Demolition of existing garage & outbuildings. Alterations to external materials (including change from thatch to clay tiled roof and brick/stone to fibre cement weatherboarding and coloured render). Alterations to existing fenestration, including to 2 no. ground floor rear bay windows, and addition of first floor front dormer, enlarged balcony at first floor level at the rear. Replacement garages.

The Breakers 29 Tamarisk Way East Preston

Thank you for your internet representation made on 25th January 2020 which has been recorded as '**an objection**' with the comments as follows:

1:100 West Elevation

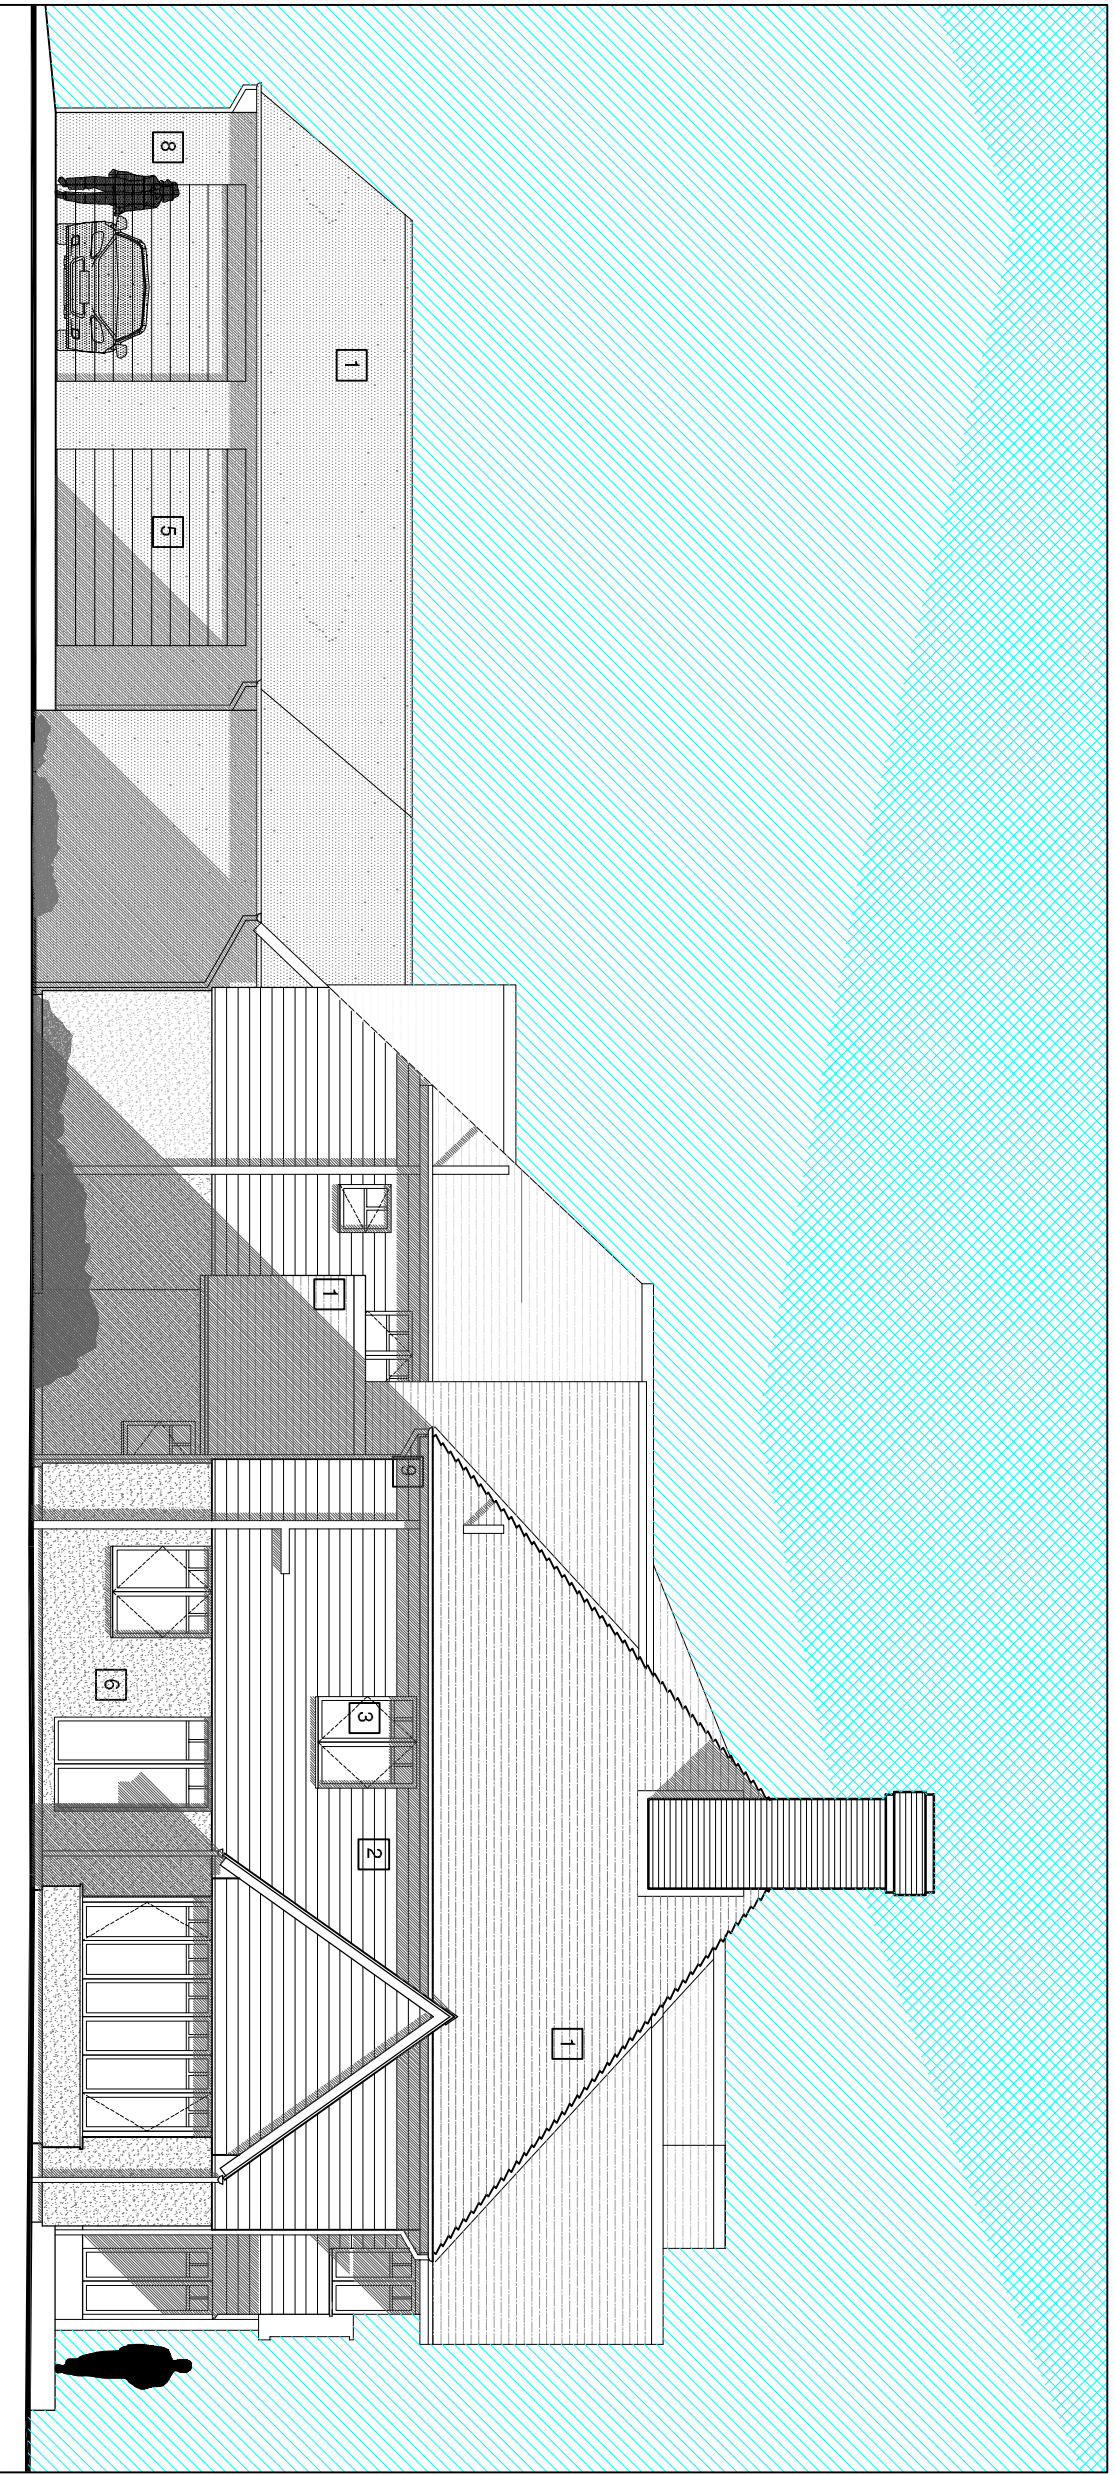
*Para.3.1 claims the property is "a hotch-potch of materials", this is clearly not the case, it presents itself as a white painted rendered building with a thatch roof and stone featured porch which is matched to the boundary wall in a characteristically open manner.*

*Replacement of this with a "New England" style property with an enclosing boundary wall, 1.95m high, would be seriously detrimental to the appearance of the area.*

*Para. 5.1 the materials proposed are completely out of character with the adjacent properties.*

*Para.6.1 the claim that replacing the thatch with the tiles will give a 100% increase in the insulation values is hard to justify. Normal modern thatch has a thermal resistance, R value, of around 5, that of the proposed clay tiles is likely to be less than 1, that is 500% worse than the thatch, so any improvement will have to be achieved by the use of secondary insulation which could likely be achieved without replacing the thatch. The windows were only replaced a few years ago, by the previous owner, with hard wood framed double glazed units, it seems unlikely that any significant improvement will be achieved with the proposed replacements. From an environmental point of view the thatch is more friendly as it is 100% carbon neutral, the replacement tiles will result in the emission of significant CO2.*
